LINCOLNSHIRE COUNTY COUNCIL'S RESPONSE TO CONSULTATION ON THE FOLLOWING DEVELOPMENT PROPOSAL

Application number: H17-0485-25

Proposal: Conversion of agricultural building into dwelling

Location: Rear of The Chestnuts, Reservoir Road, Surfleet, Spalding, PE11 4DH

PROPOSED BLOCK PLAN

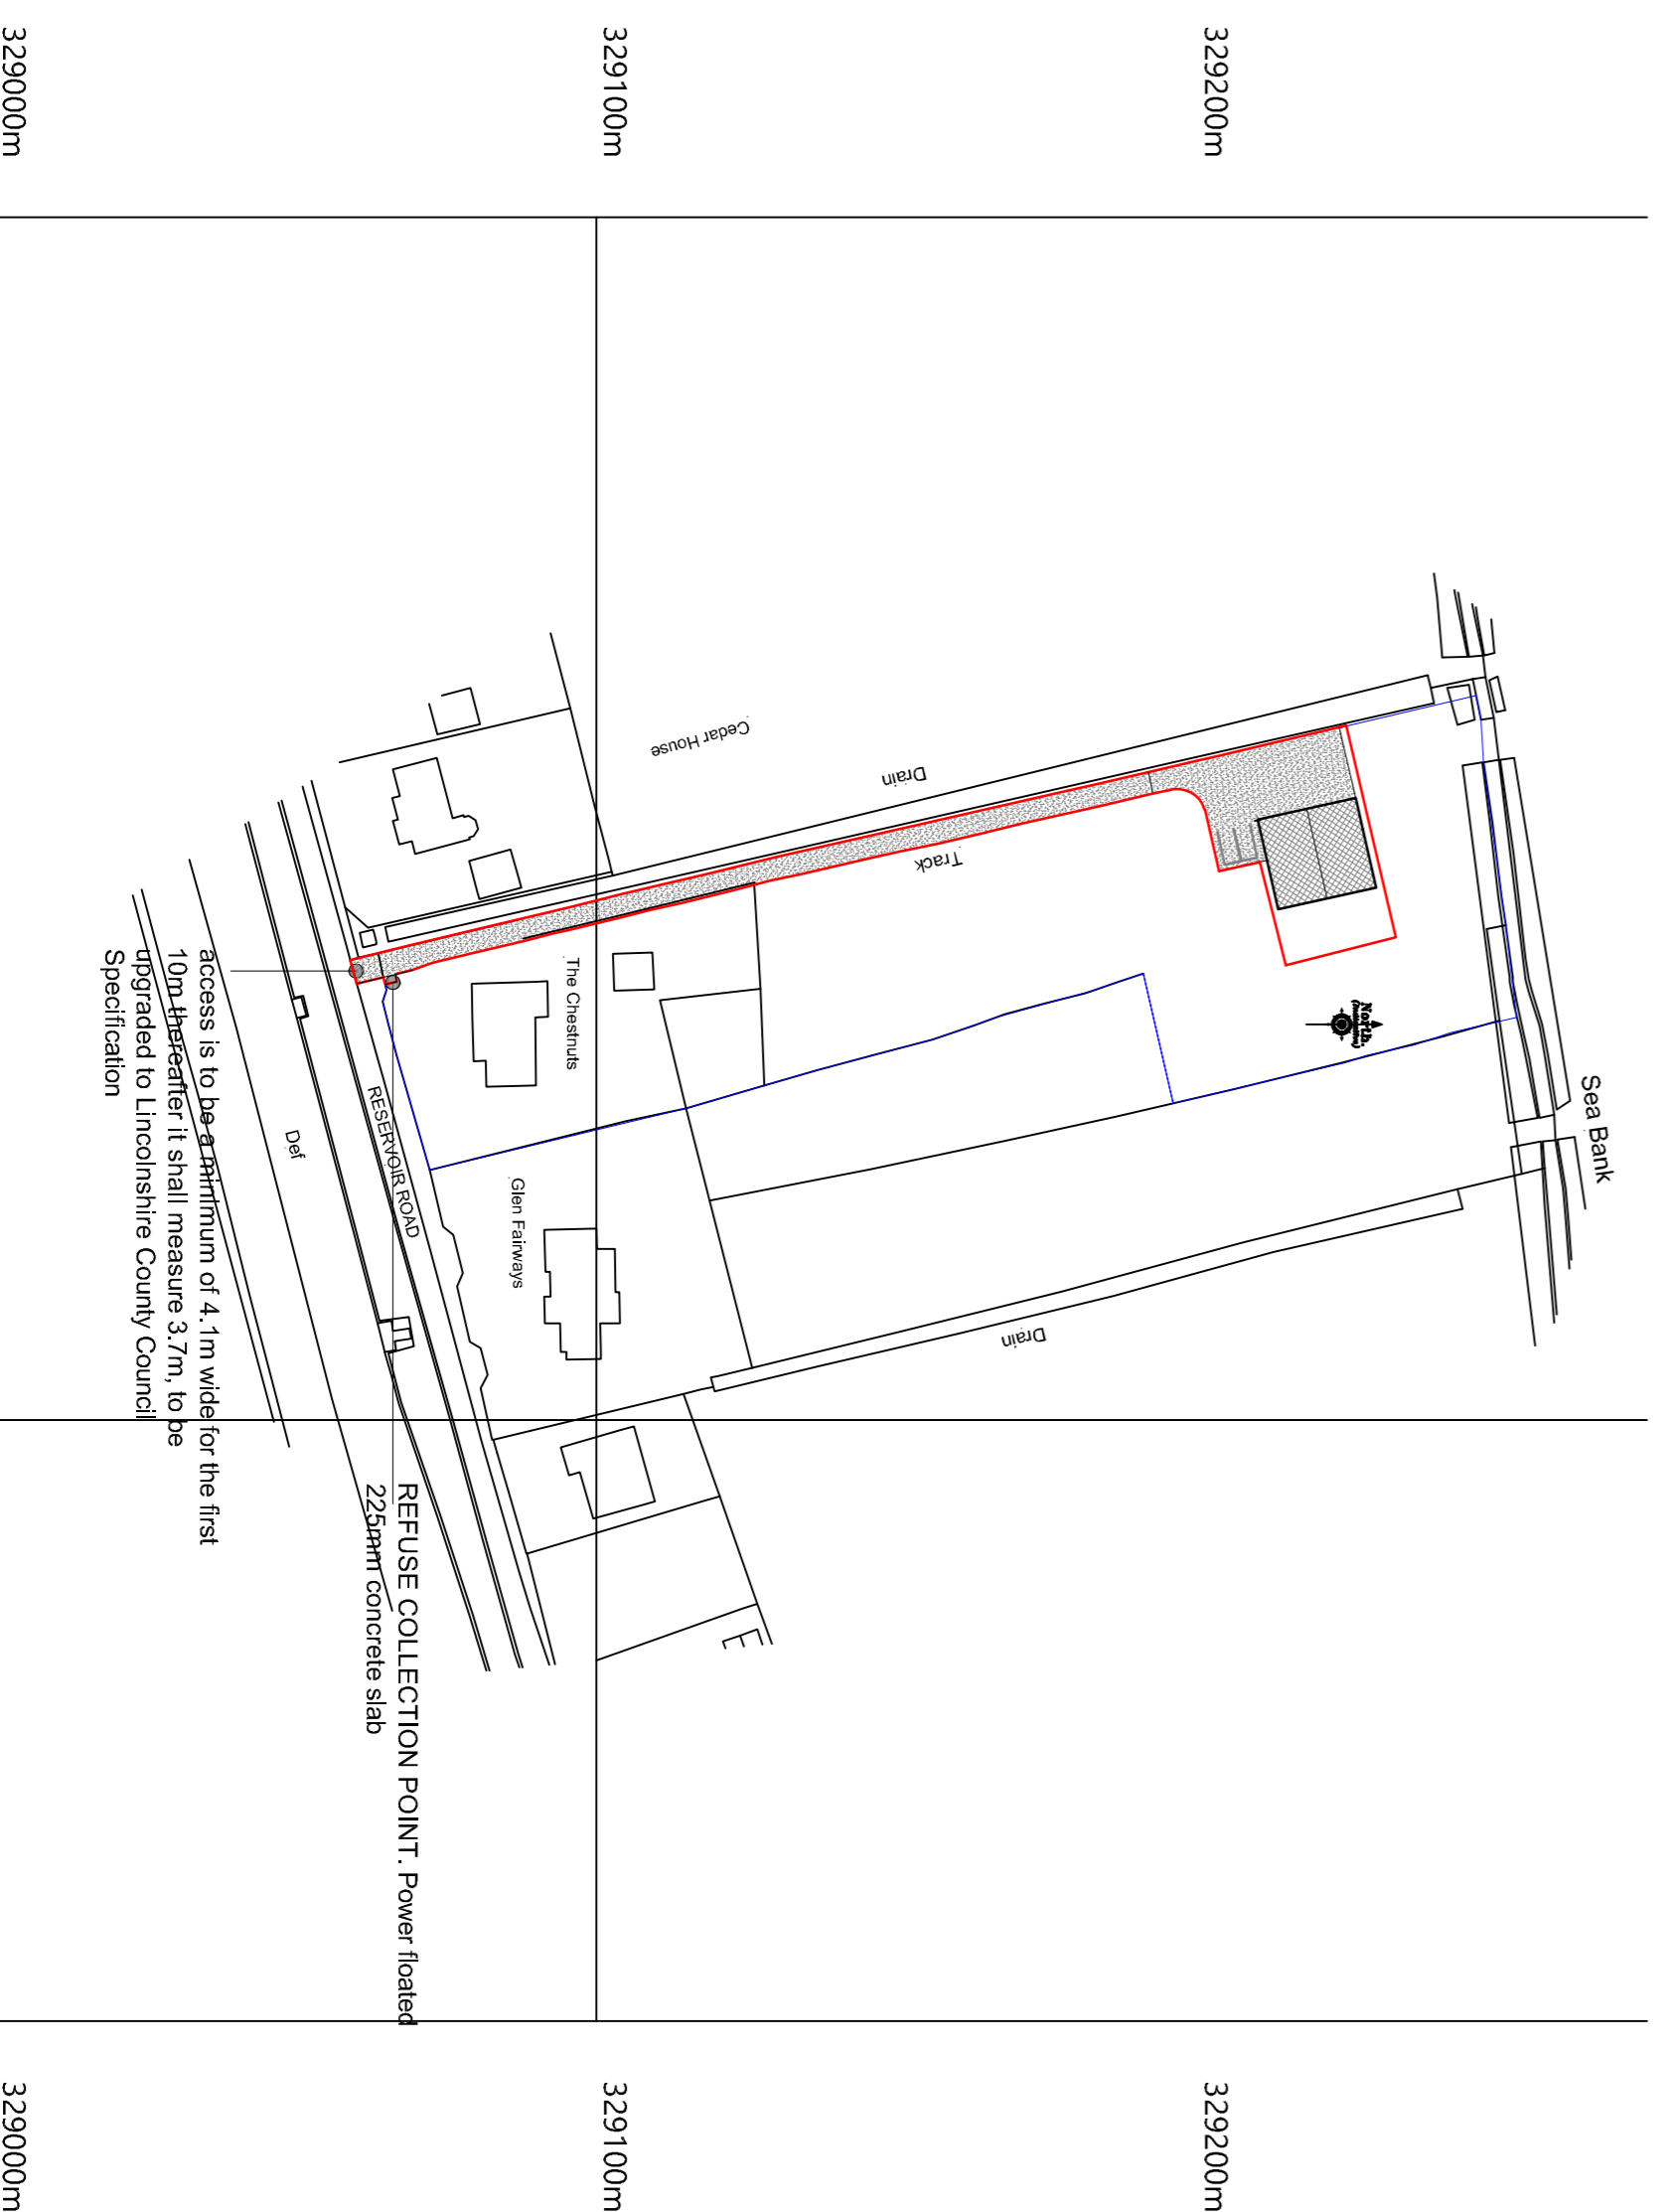
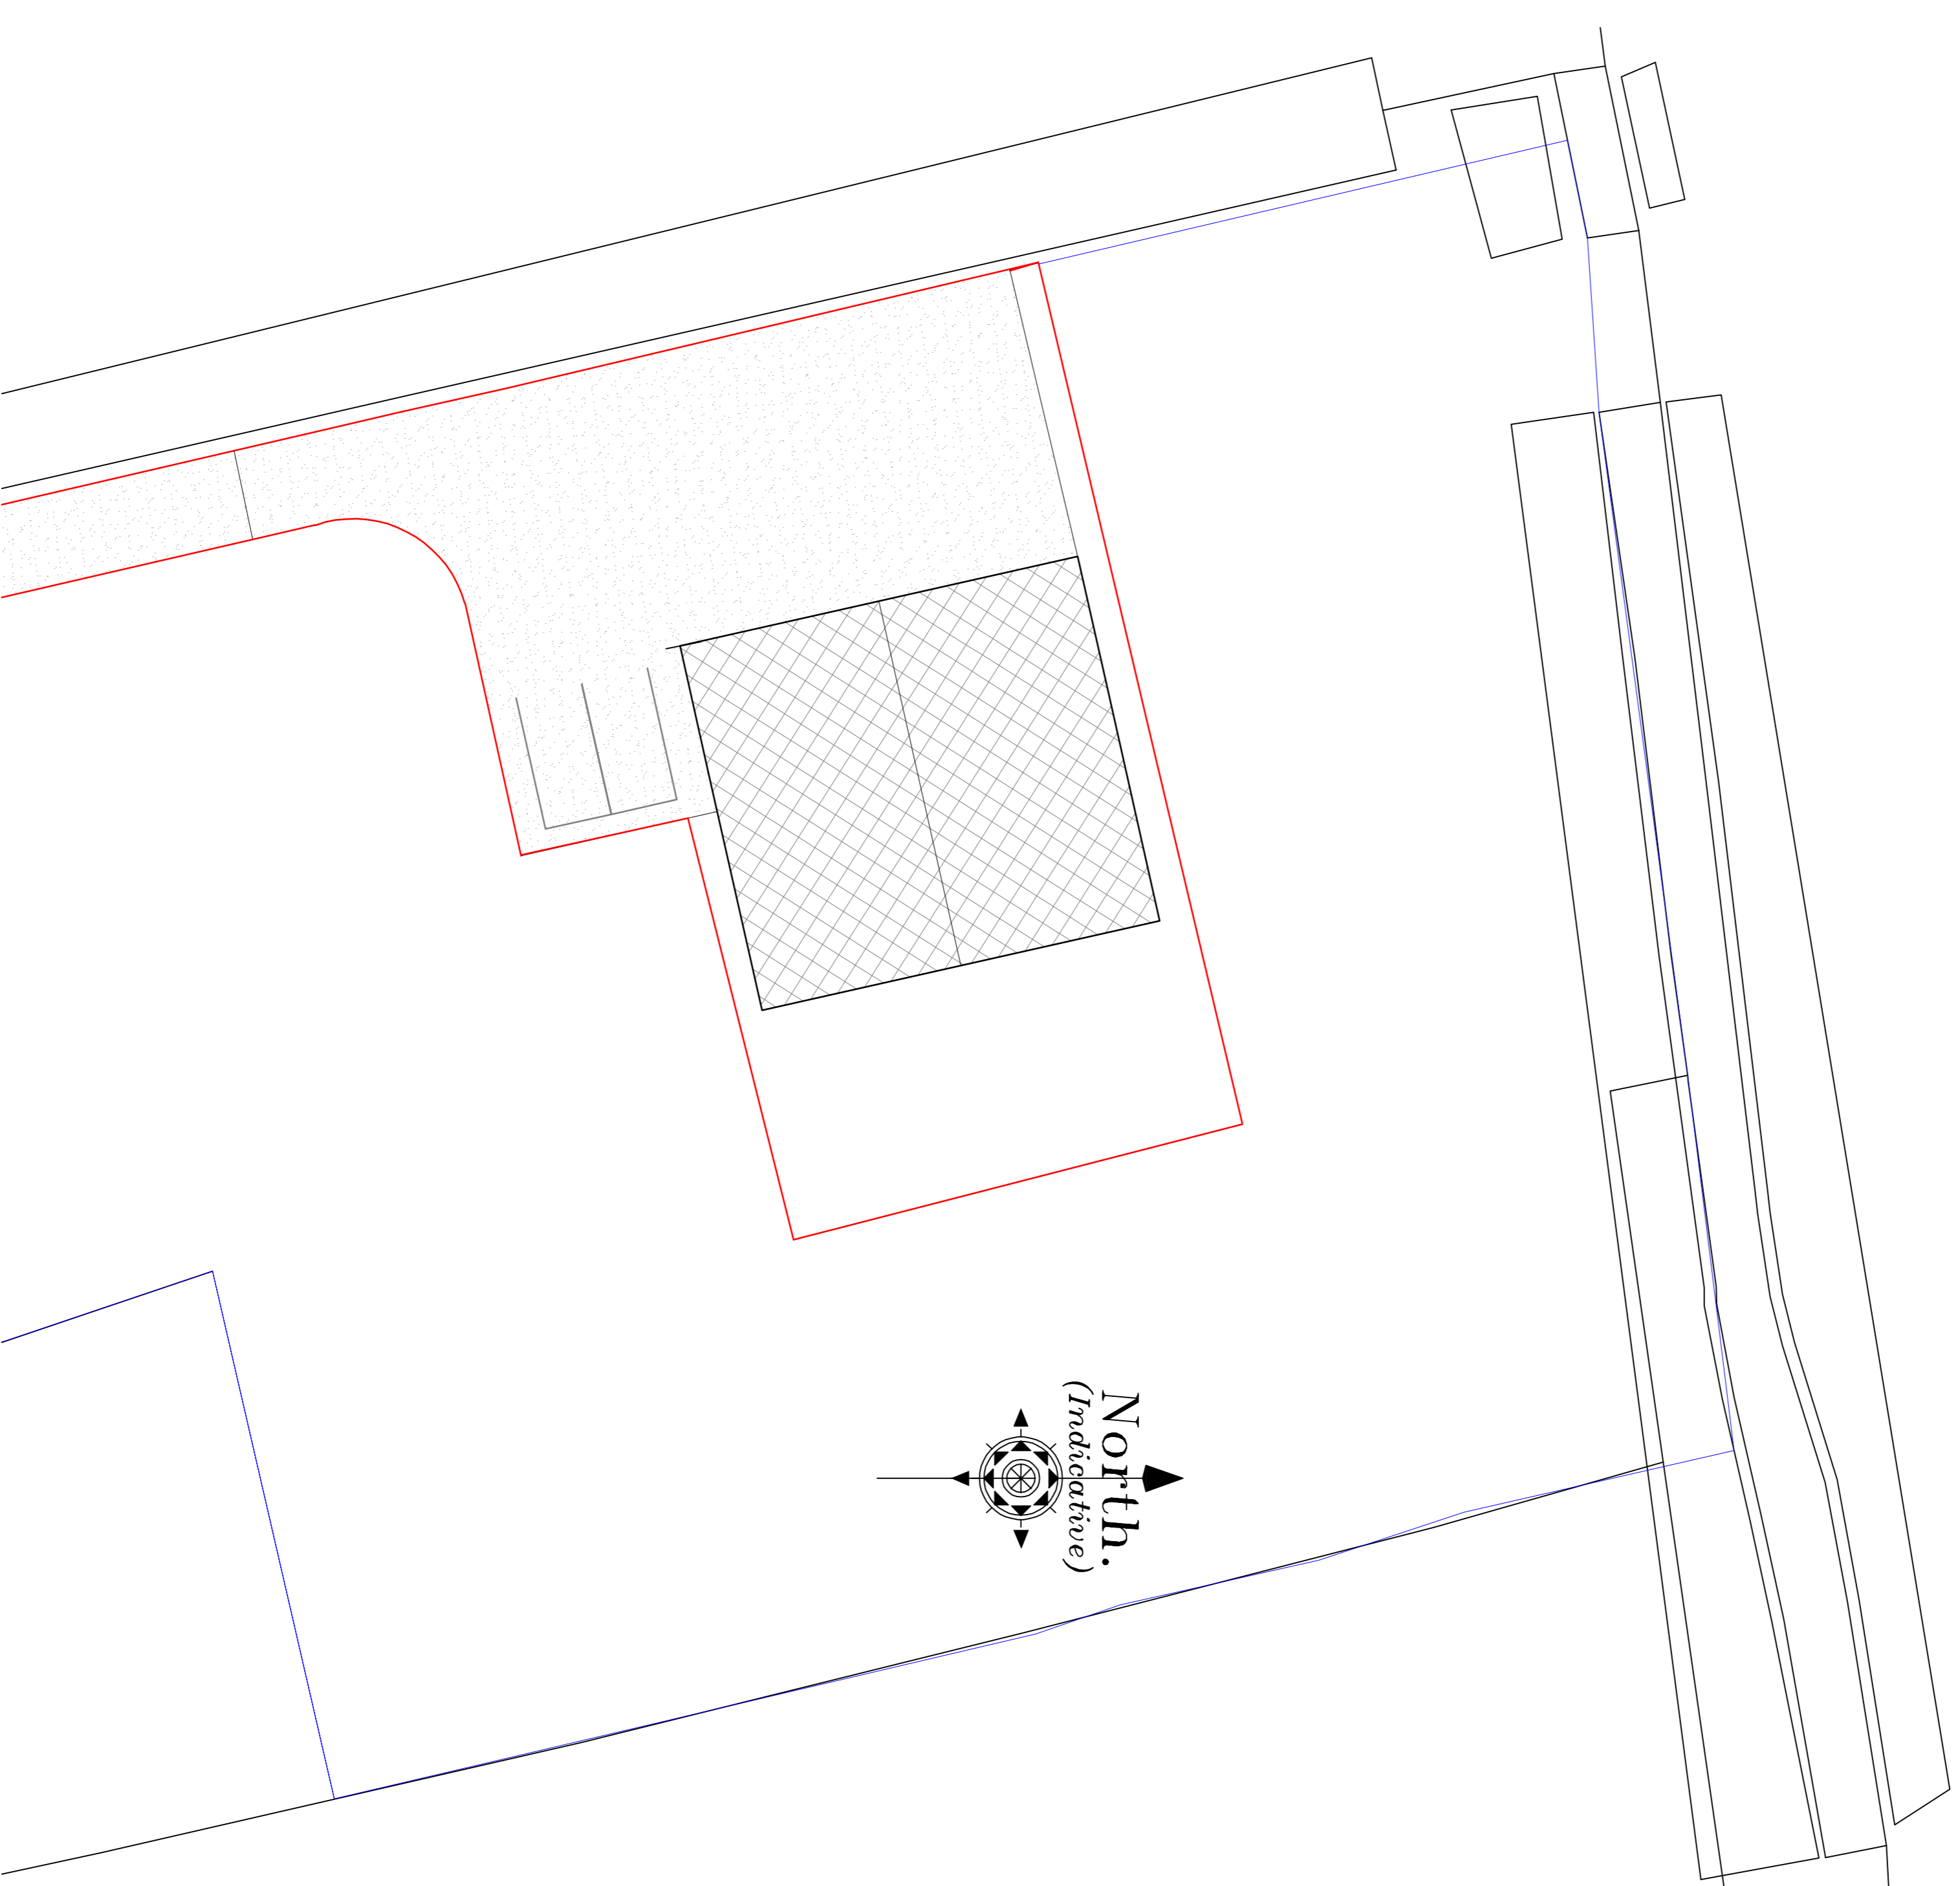
That said, the existing vehicle access is not appropriate for this or current use as it is just an unbound material and therefore, it will need to be made up to the County Councils specification within the extent of the public highway appropriate for its proposed residential use.
